South West Forest Services

Application by Highways England (the Applicant) for an Order granting Development Consent for the A417 Missing Link (the Proposed Development)

Scoping consultation and notification of the Applicant's contact details and duty to make available information to the Applicant if requested

Location: A417 Gloucestershire

IN ADDITION TO THE HAZARDS/RISKS NORMALLY ASSOCIATED WITH THE TYPES OF WORK DETAILED ON THIS DRAWING, NOTE THE FOLLOWING SIGNIFICANT RESIDUAL RISKS (REFERENCE SHALL BE MADE TO THE DESIGN HAZARD LOG).

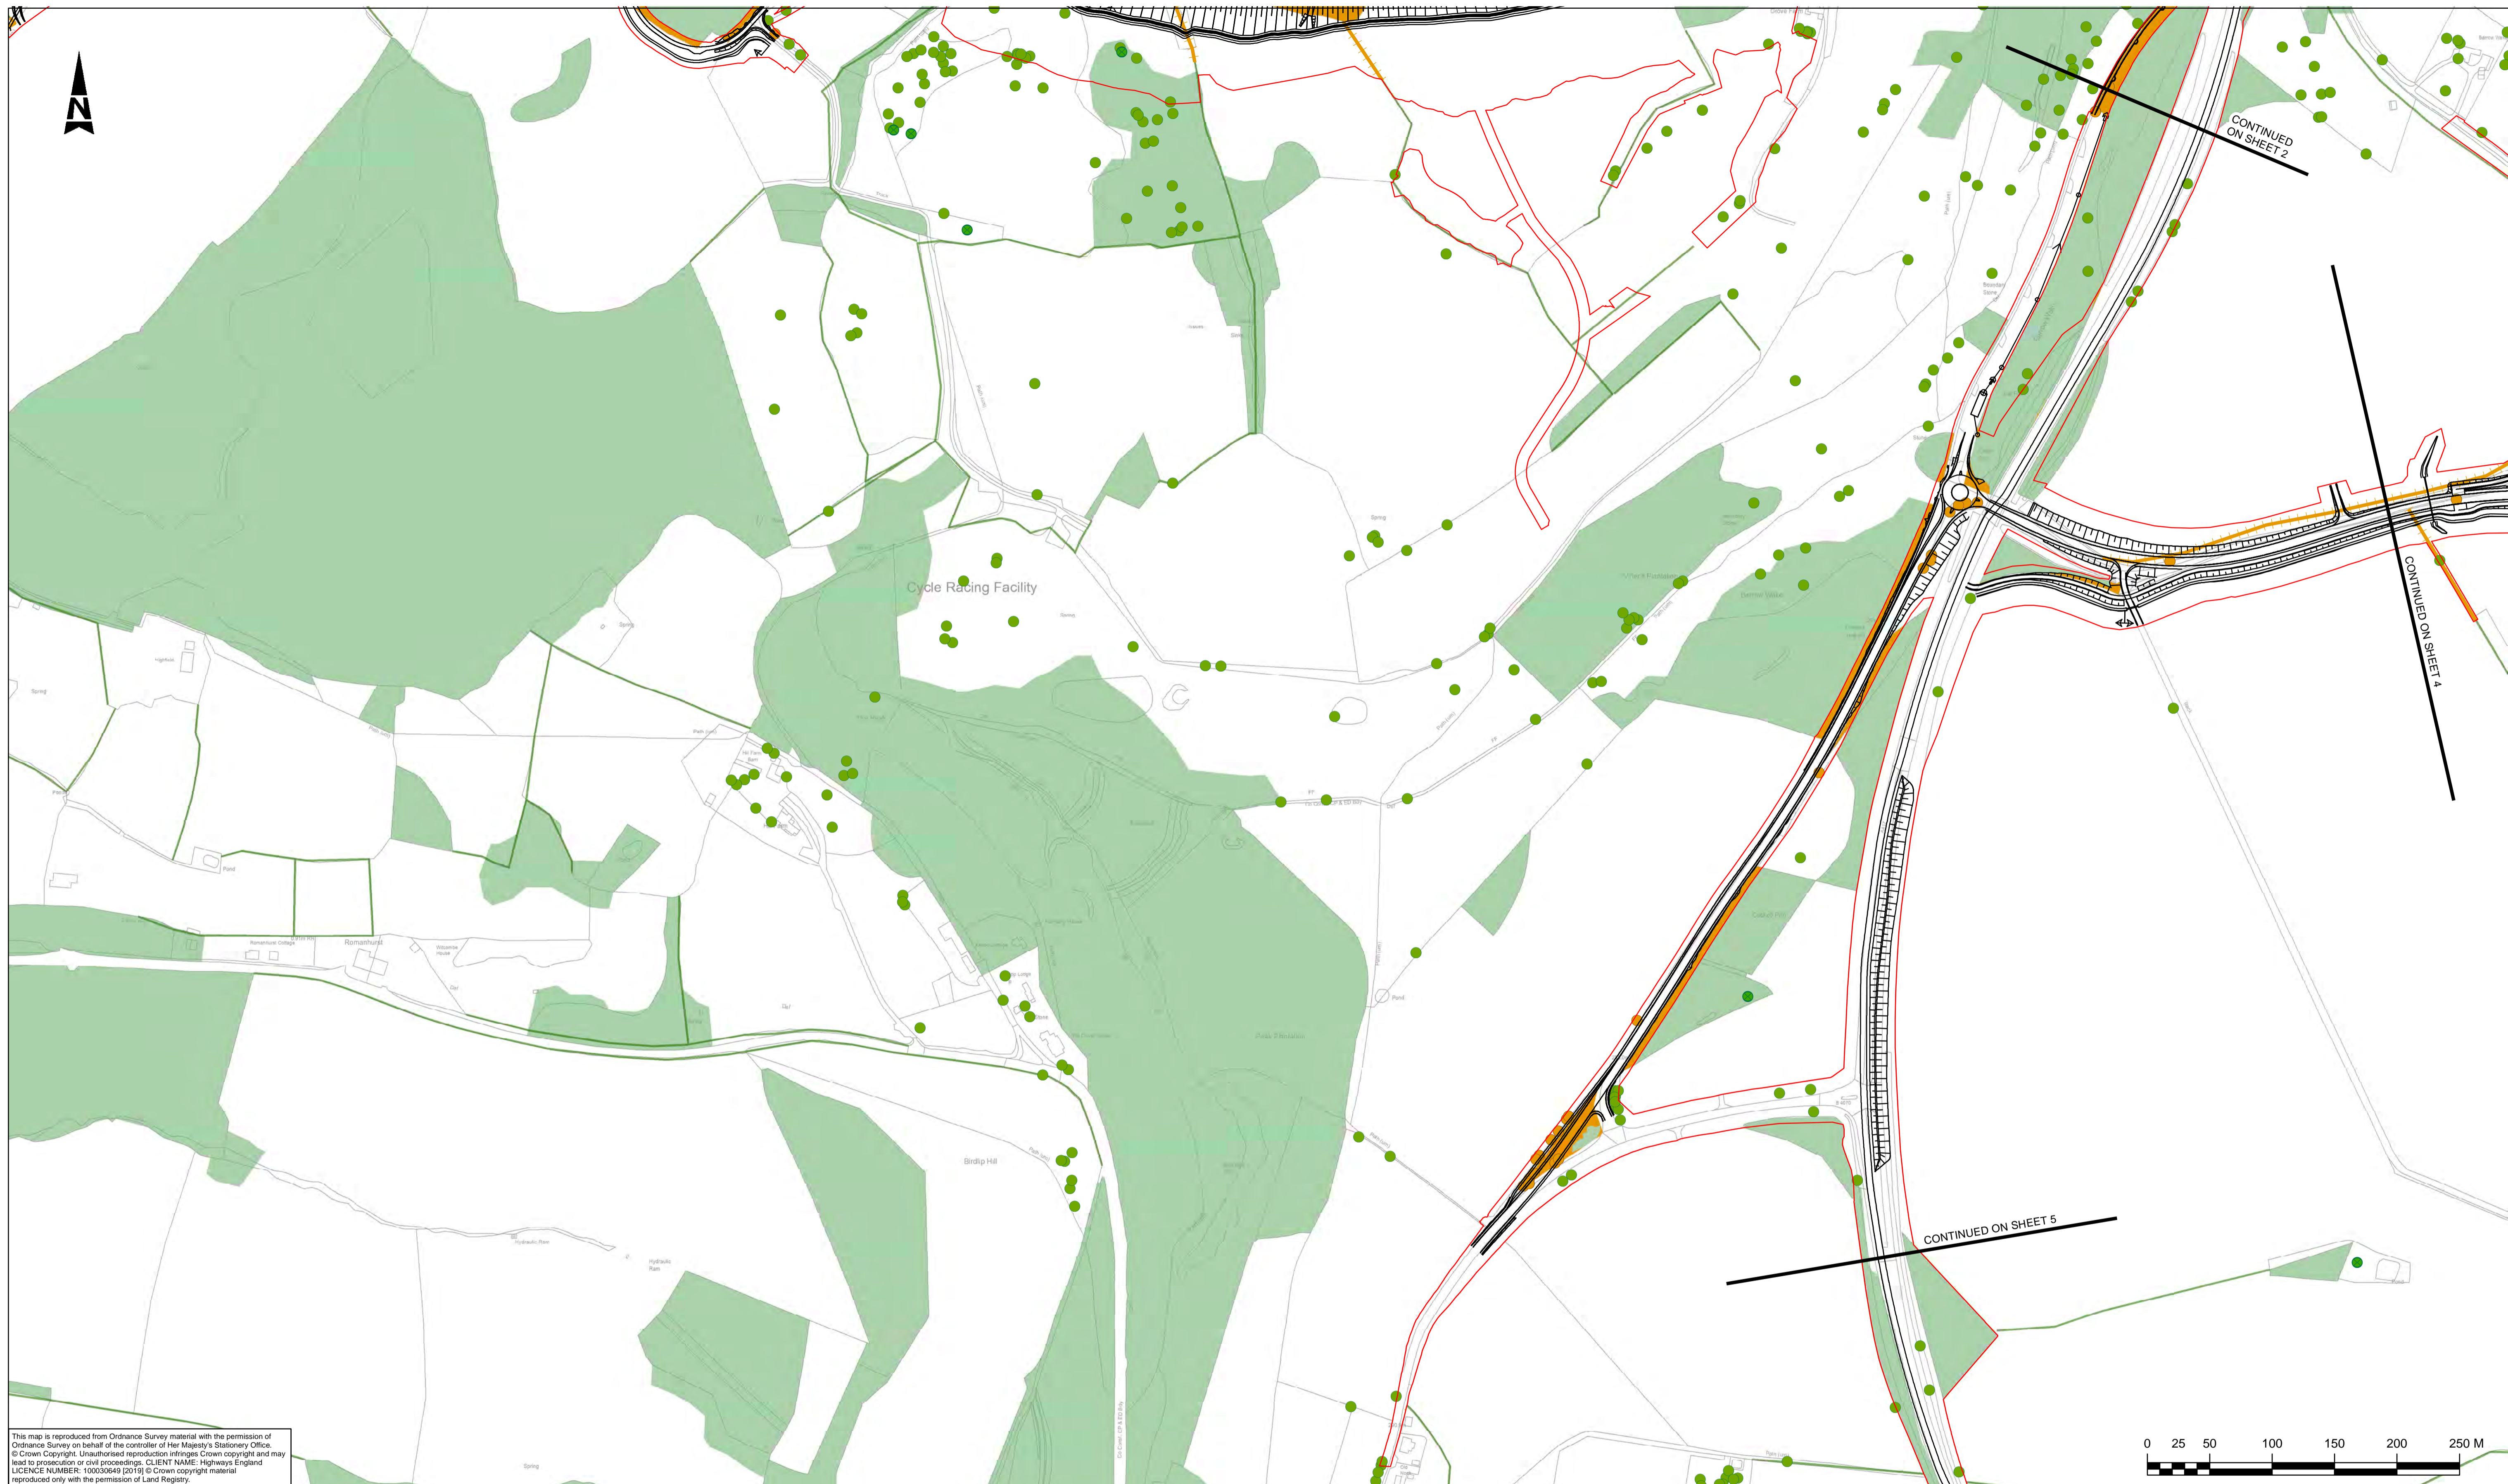
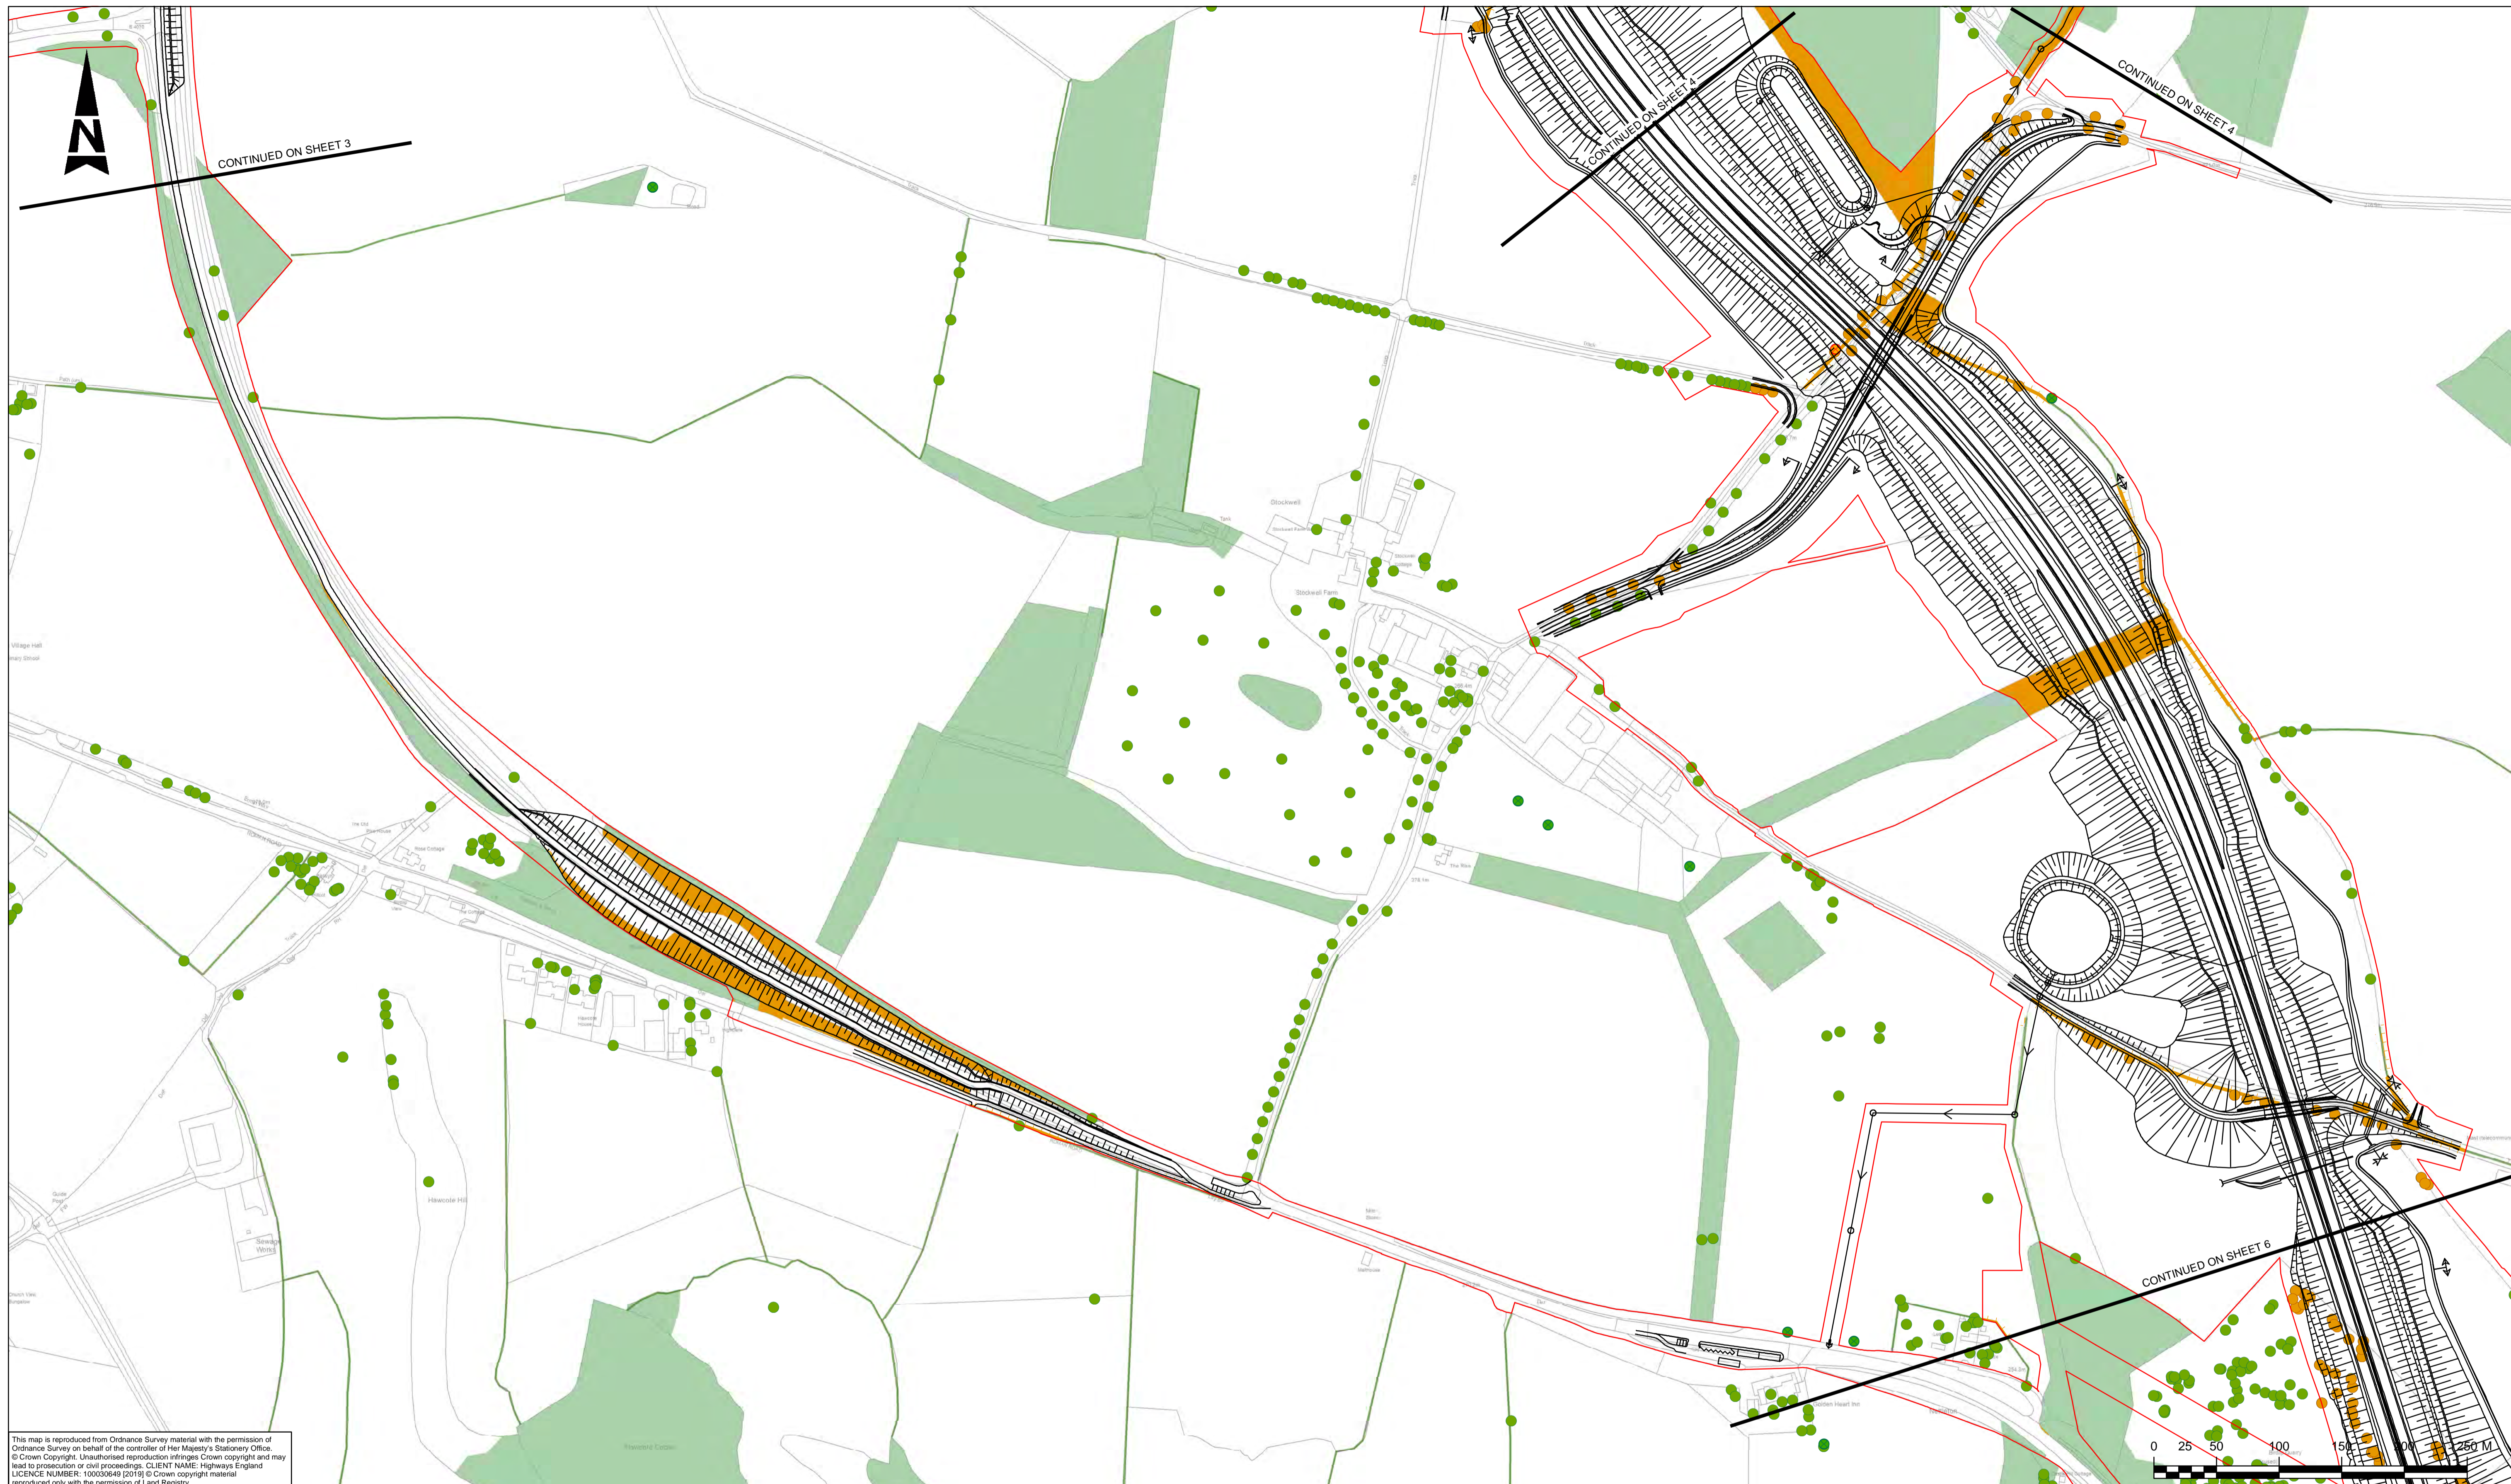
I note that there is a proposal to remove an area of presumed ancient semi-natural woodland which is too small to be on the register but which will be treated as ancient woodland. Our advice would be that no presumed ancient woodland should be removed. It is important that there is no net deforestation so any loss of woodland should be compensated for. Ideally schemes will lead to an increase in woodland cover.

Although there are no large woodlands on the proposed route, there are several existing felling licences and woodland grant agreements in the vicinity of the proposed scheme. It will be important to ensure that the new scheme design does not make it difficult to access and manage any existing woodlands, or to make the recreational use of woodland less enjoyable. Ideally it will enhance opportunities to access, carry out work and extract timber from sustainably managed woodlands.
